**EL PASO COUNTY PLANNING AND
 COMMUNITY DEVELOPMENT
 DEPARTMENT**

GRADING AND EROSION CONTROL PLAN CHECKLIST

Revised: July 2019

MATCHLINE ~ (SEE SHEET 4)

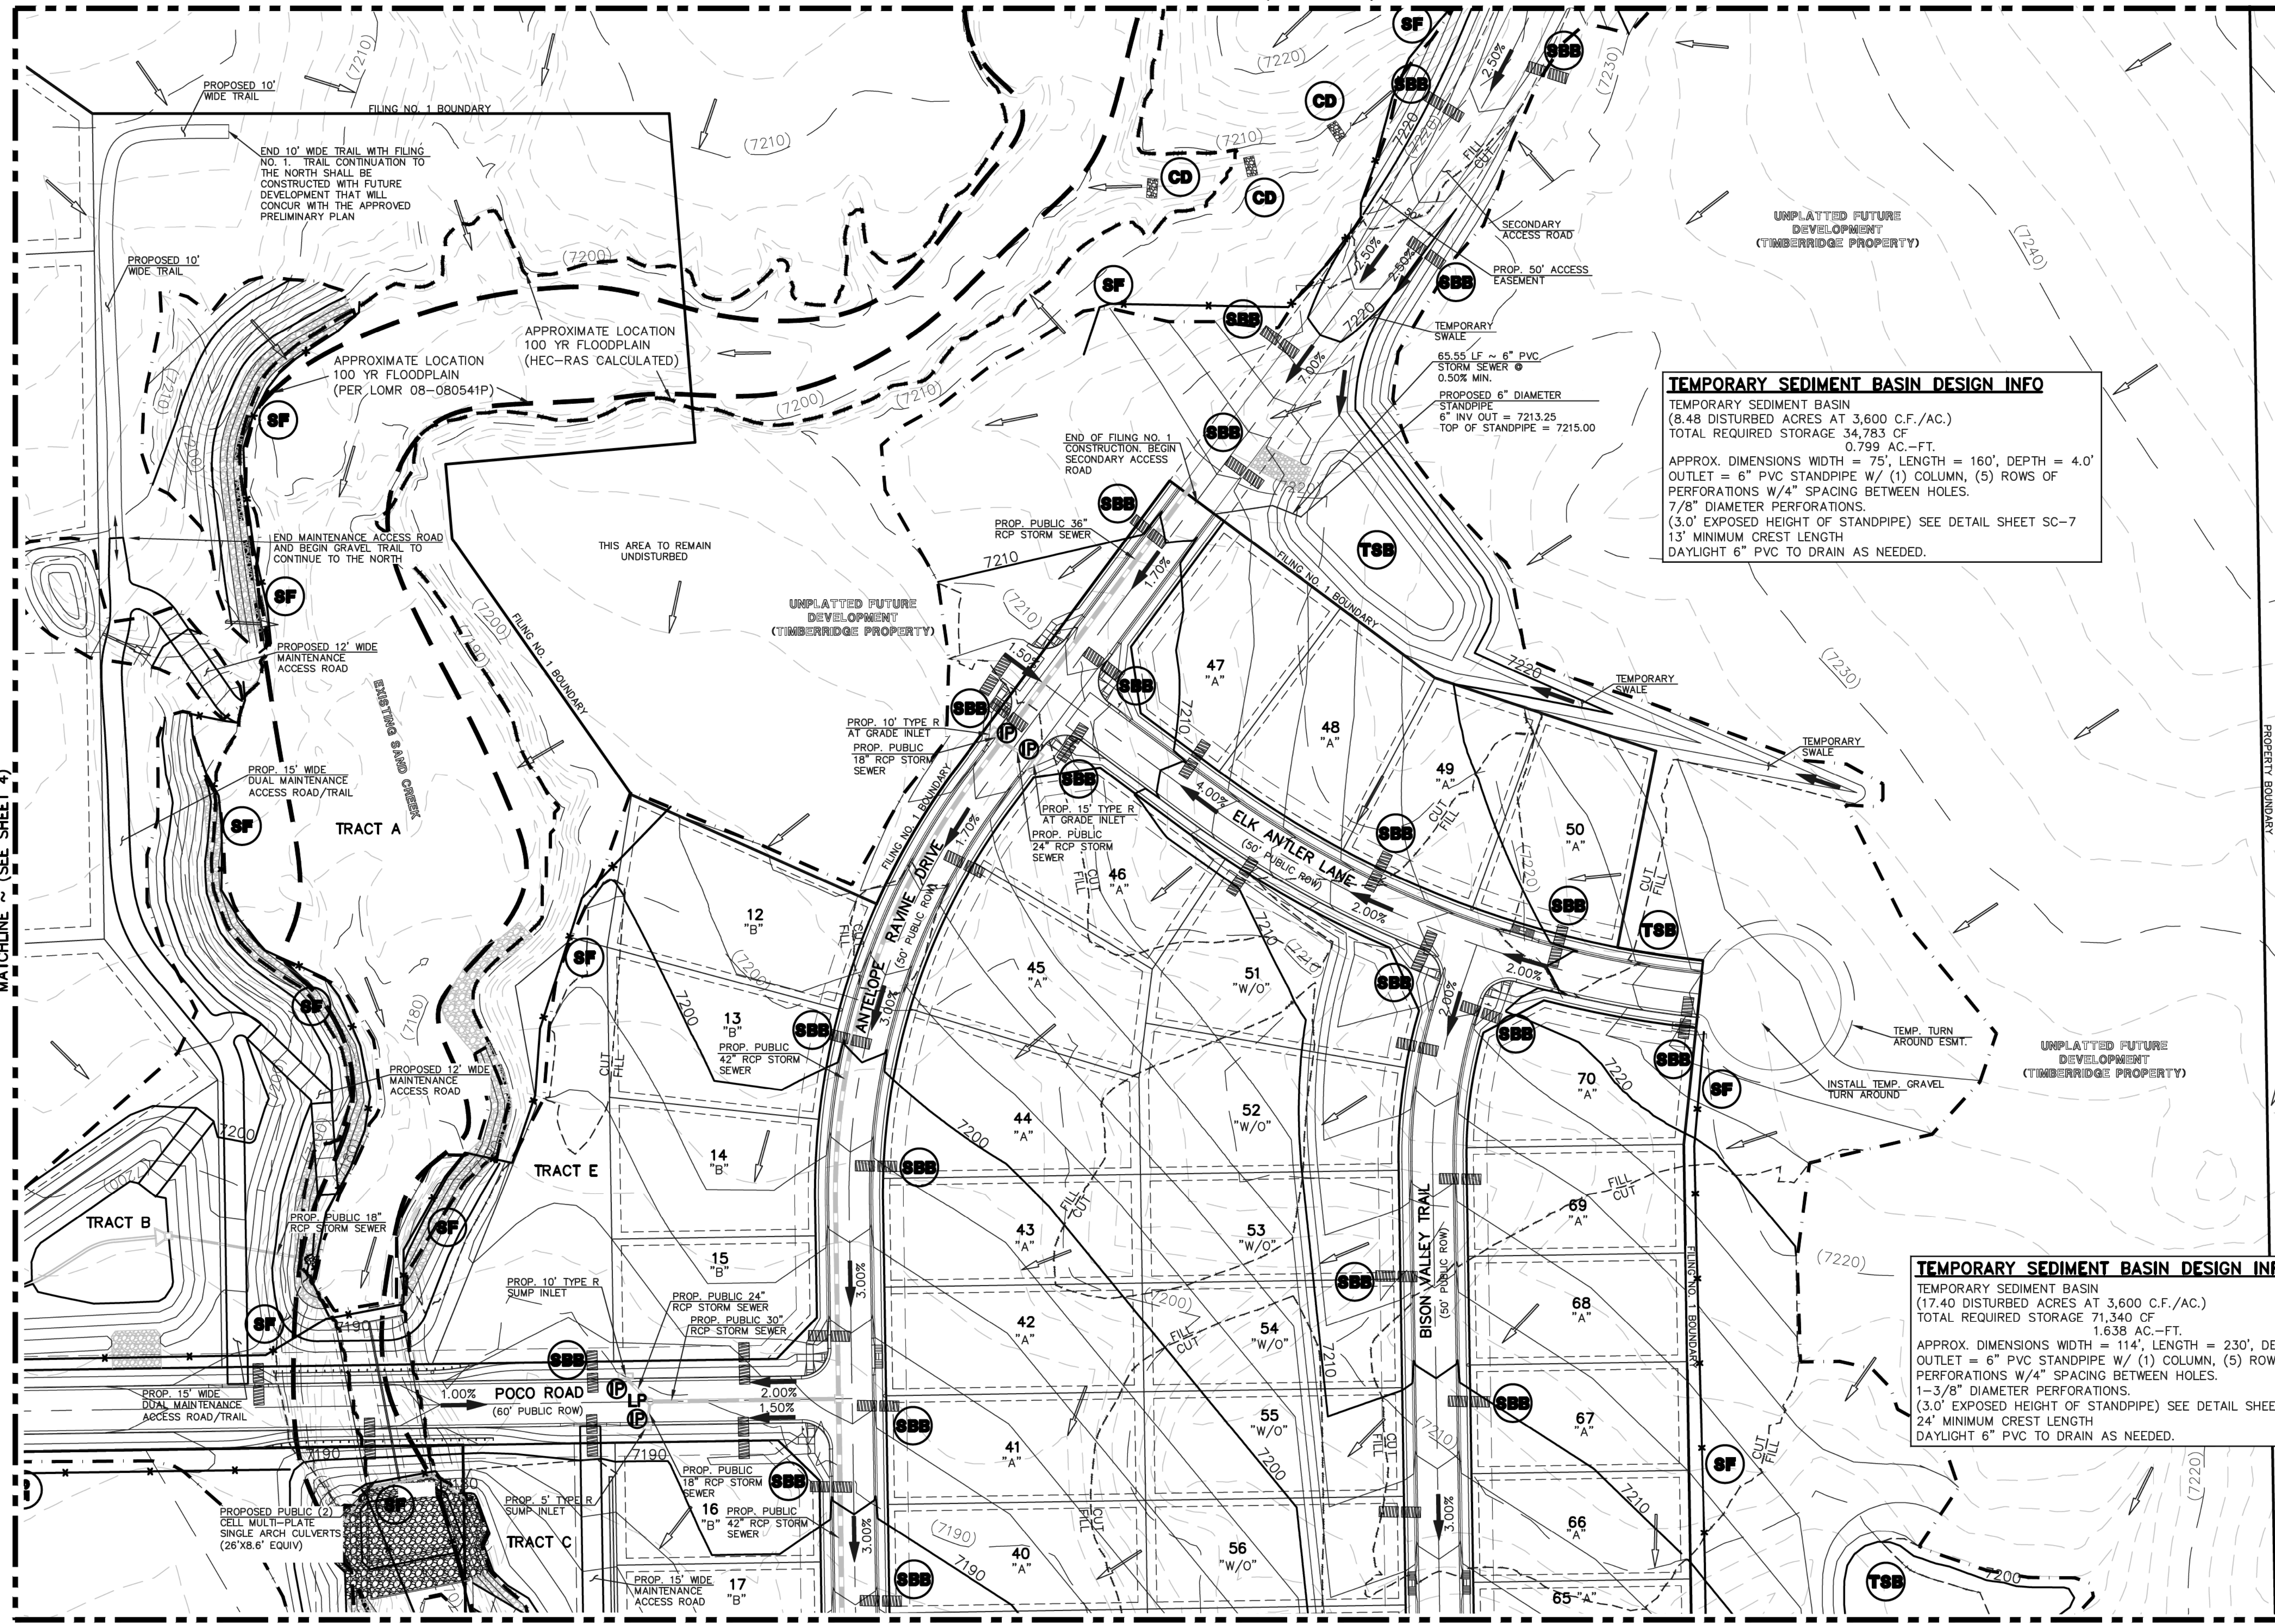
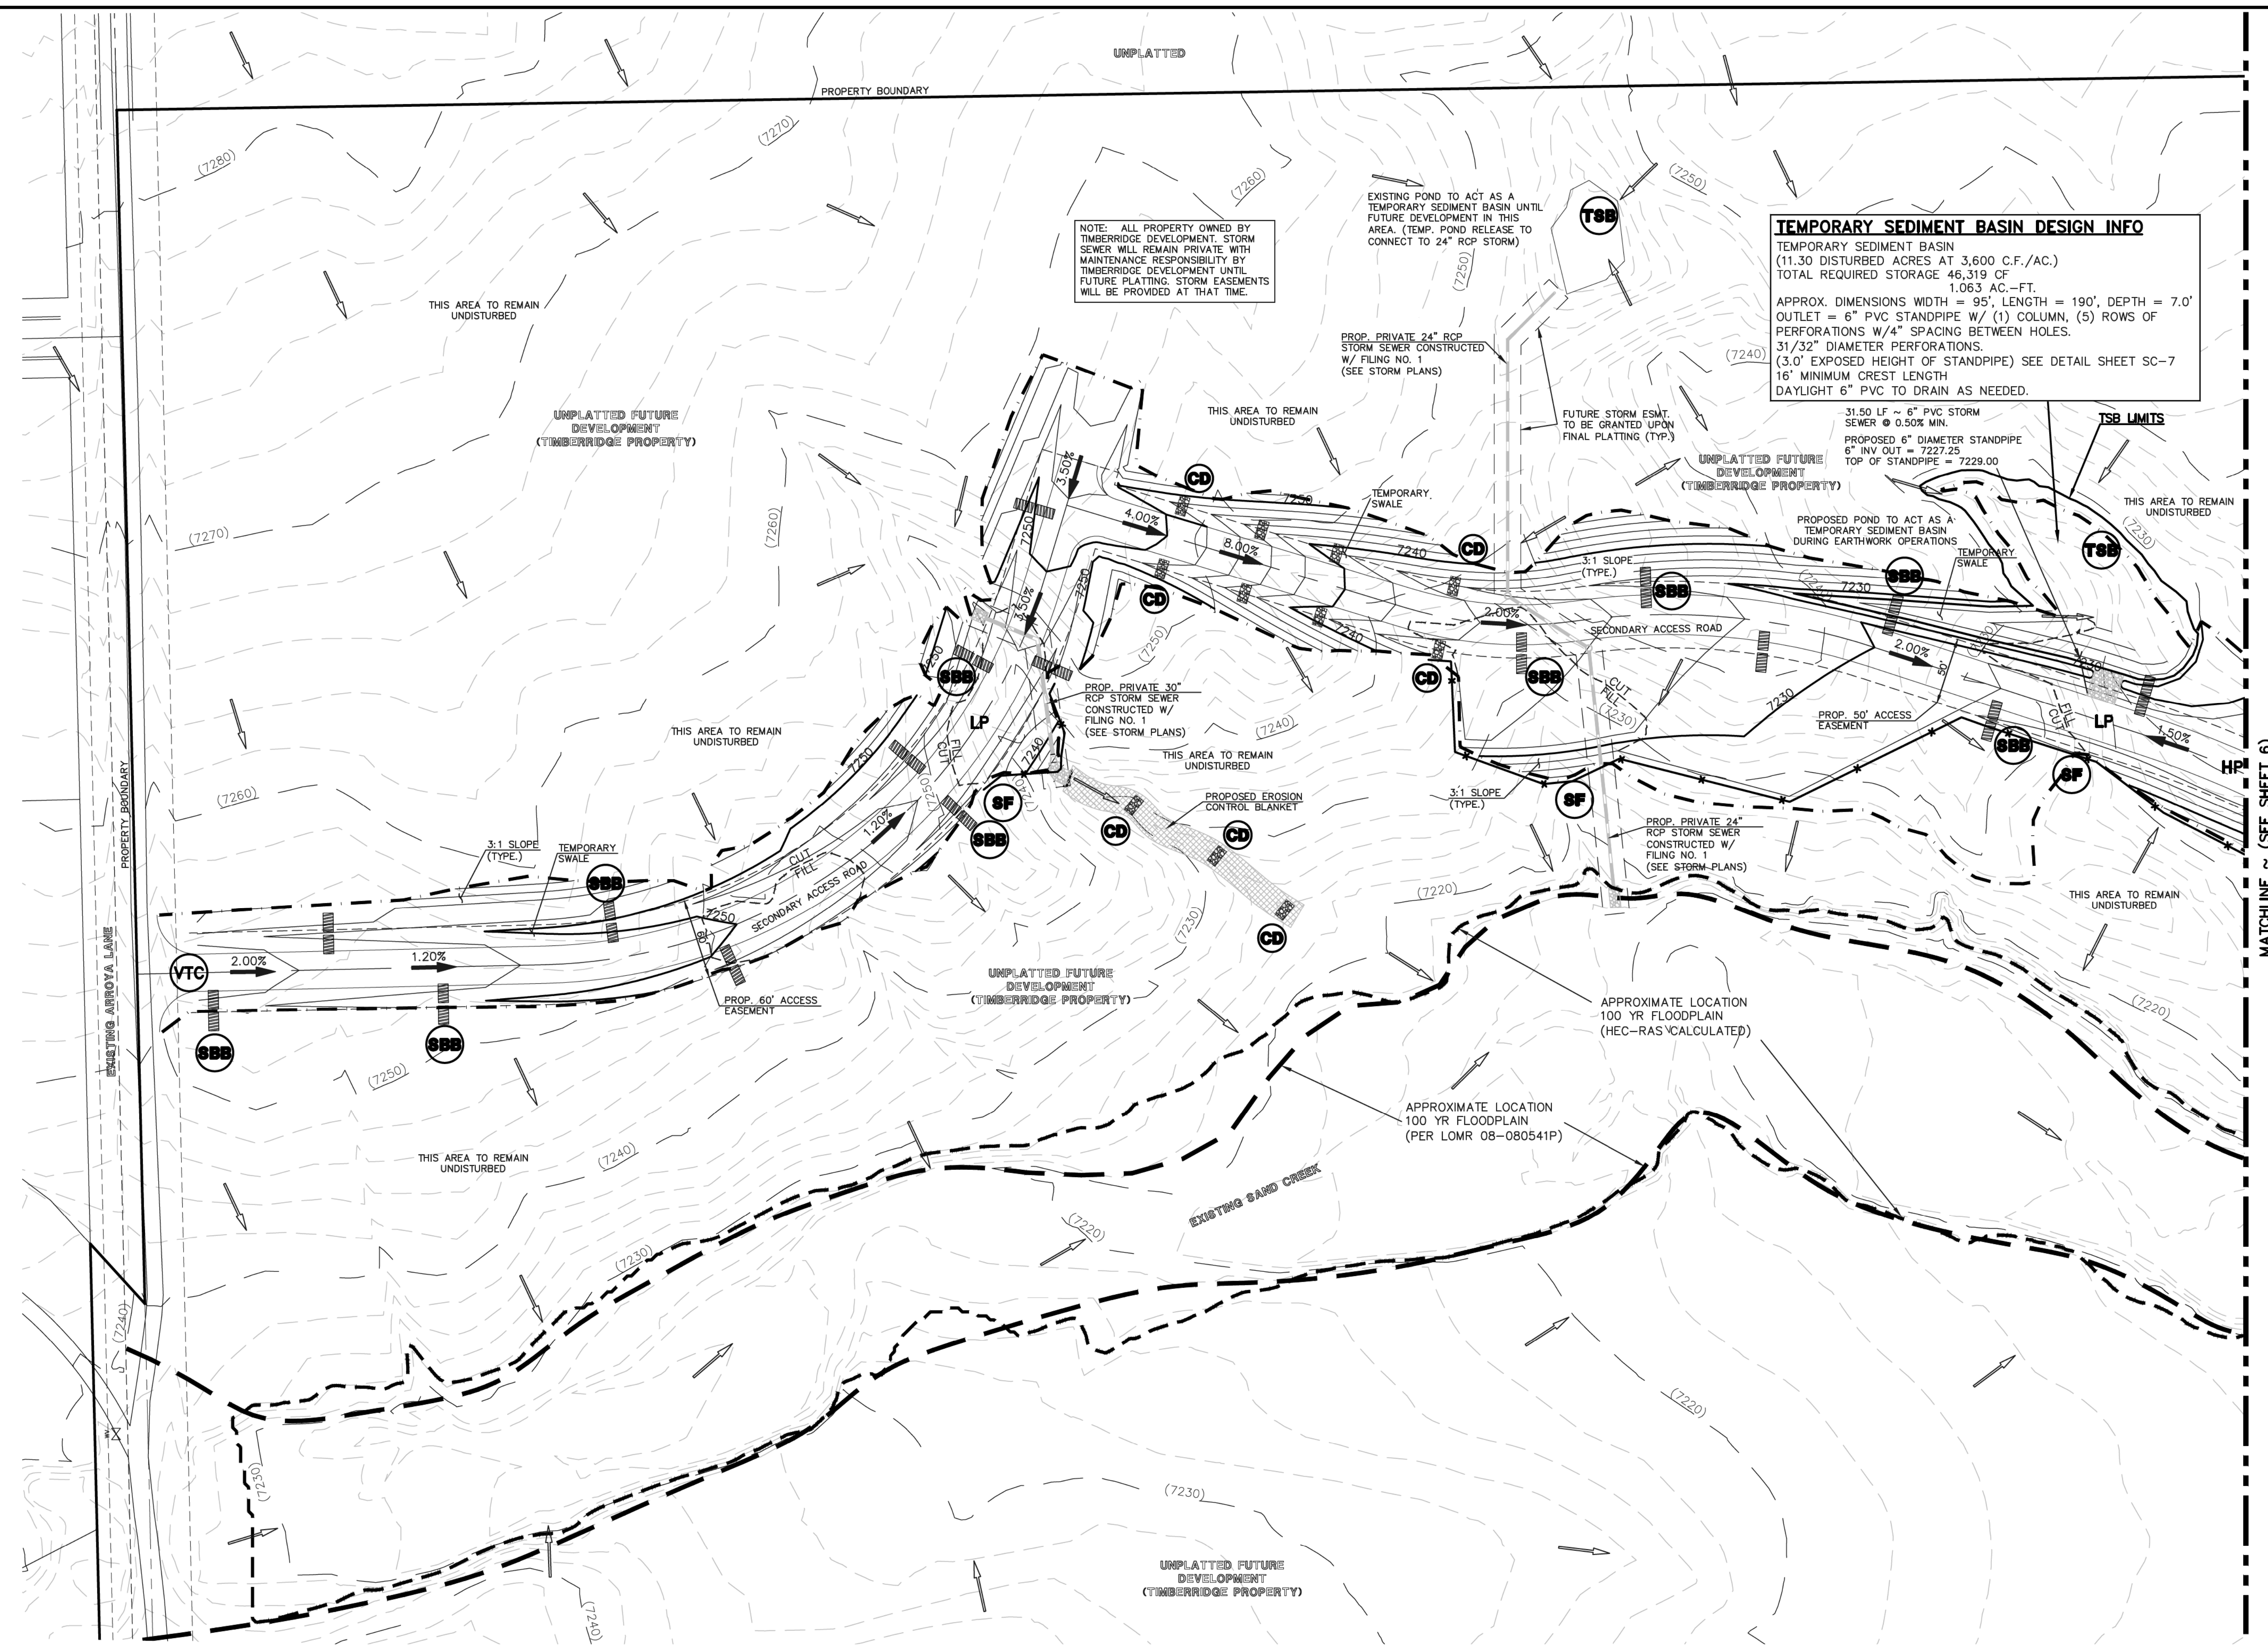
v	All proposed temporary construction control measures, structural and non-structural. Temporary construction control measures shall be identified by phase of implementation to include "initial," "interim," and "final" or shown on separate phased maps identifying each phase.	X	✗
w	Vehicle tracking provided at all construction entrances/exits. Construction fencing, barricades, and/or signage provided at access points not to be used for construction.	X	✓
x	Temporary sediment ponds provided for disturbed drainage areas greater than 1 acre.	X	✓
y	Dewatering operations to include locations of diversion, pump and discharge(s) as anticipated at time of design.	X	✗
z	All proposed temporary construction control measure details. Custom or other jurisdiction's details used must meet or exceed EPC standards.	X	✓

update notes on plan
